From: Julie Grieves on behalf of Planning.Responses
Sent: 08 September 2017 09:46
To: Planning Scanning
Subject: FW: Planning Consultation on: LU/234/16/RES

Comment from Greenspace

Further to submission of application LU/234/16/RES and the submission of revised plans A088461 FL1 & FL2 REV H we can confirm that the amendments have considered our comments and have now included a scheme which does adequately address the lack of native planting and screening to the eastern and school boundary aspect of these proposals. The species choice and mix is suitable for location and purpose.

Registered: 31st August
2016
Site Address: Fitzalan Link Road Littlehampton
Grid Reference: 503155 102602
Description of Works: Application for reserved matters relating to access, appearance, landscaping, layout and scale of the previously approved LU/63/11/. This application affects a Public Right of Way

Plant schedule

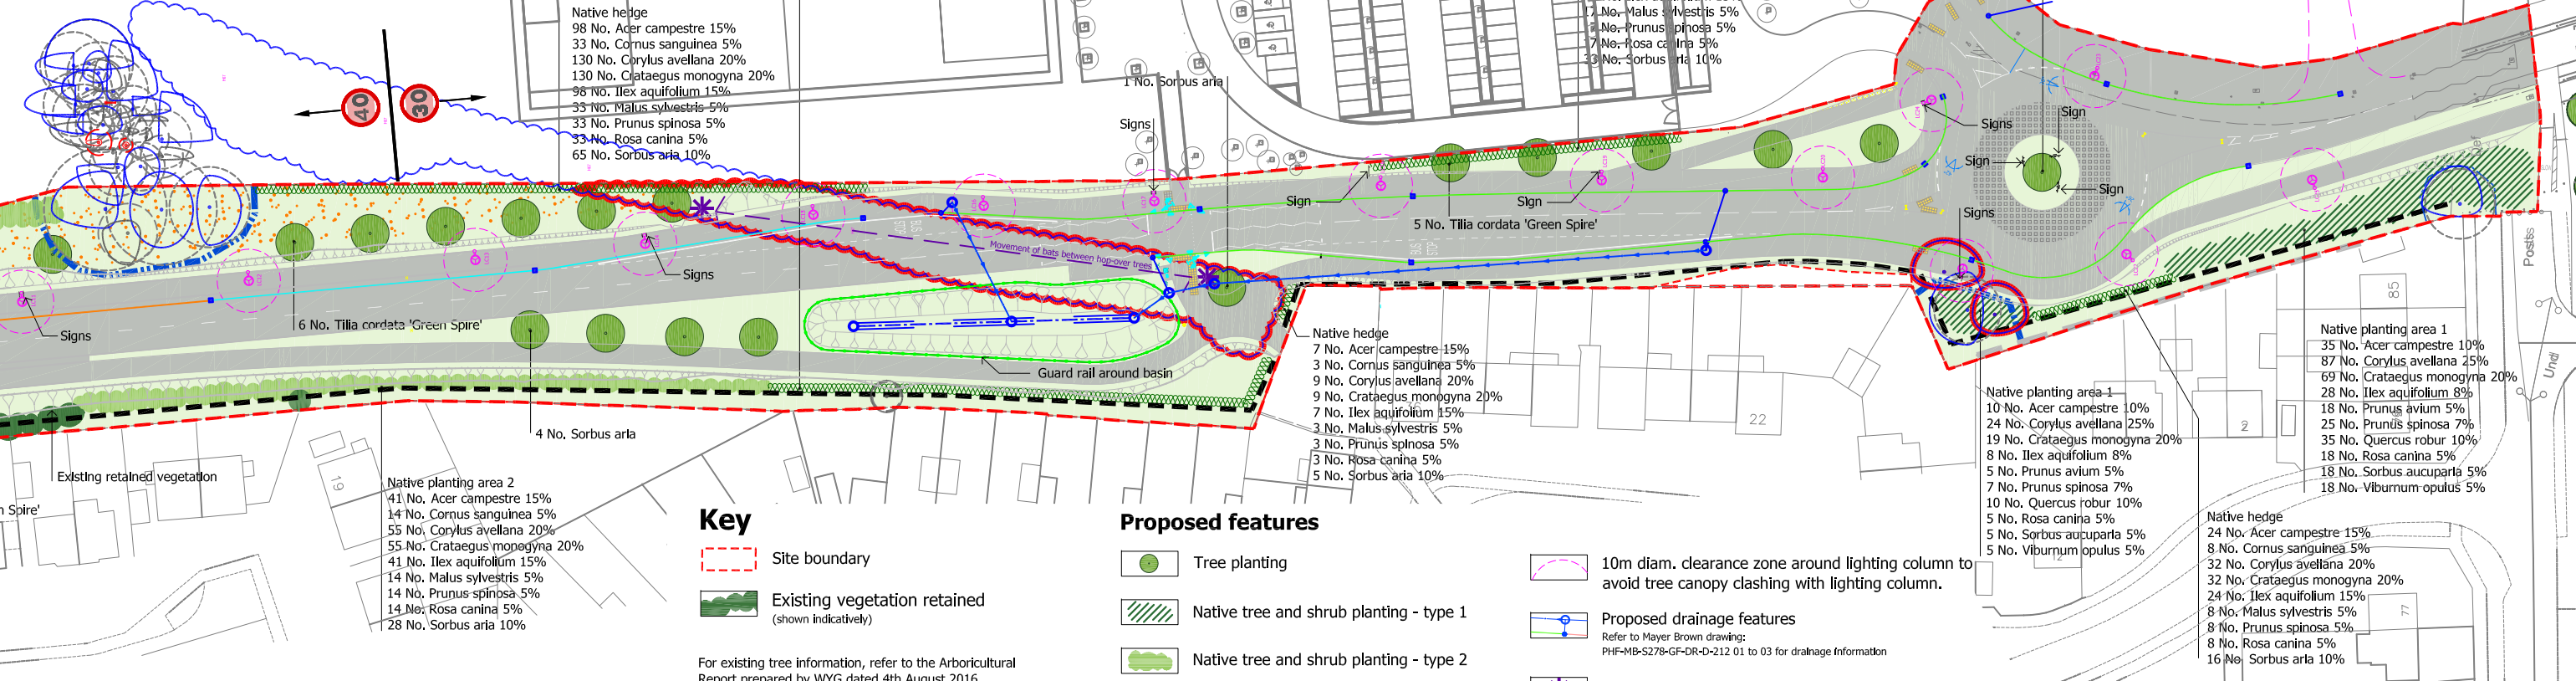
The landscape scheme proposed under this reserved matters application contained in drawings A008461 FL1&2 (C) in general provides a good species selection of mixed native evergreen and deciduous trees and shrubs, which if given the correct protection and aftercare would create a suitable scheme. The details show proposed planting located particularly to the west of the proposals adjoining the existing housing, which when established with the existing retained vegetation will provide screening and buffer zone benefits in this area. The semi mature tree detail re species choice, sizes and location of planting we feel is adequate for the location in that over time it will help soften the proposals into the surrounding landscaping providing a greening along this roadway. The tree species chosen will produce trees with a reasonably compact head form which obviously has been considered in relation to spread, sight lines and street lighting. Generally a mix of species would be preferred to give greater biodiversity to the scheme however the tree sizes indicated will provide instant impact and will help to mitigate for those lost within the proposals.

Whilst there is a good spread of amenity trees at a semi mature size incorporated into the scheme to both sides of the proposals the understory native planting is proposed predominantly to the western side. Consideration should also be given to the eastern aspect which adjoins the school, where the proposals are presently inadequate, it would be advised that understory natives should also be incorporated along this edge and to the open areas where landscaping was indicated in the original LU/63/11 application. Screening to this eastern aspect is required and also consideration given to the views beyond, the formation of a green link and habitat corridor to this fringe of the proposals being required.

Clarification should be provided on the landscape layout plans as to the spacing of the native transplant planting being proposed so that a clear picture of proposed density and how quickly this will establish can be seen.

Protection measures along with a comprehensive maintenance regime would need to be in place to ensure that the planting does establish, thrive and develop to the screen suggested. This would be particularly relevant to the semi mature trees being proposed which would form an important statement along these proposals. The future long term maintenance should also be considered post establishment regarding the tree protection methods initially employed, these will require a strategy in place for their ultimate removal once no longer required and before they become a litter issue and hazard.

Detail of maintenance regime and long term maintenance management has also now been provided.
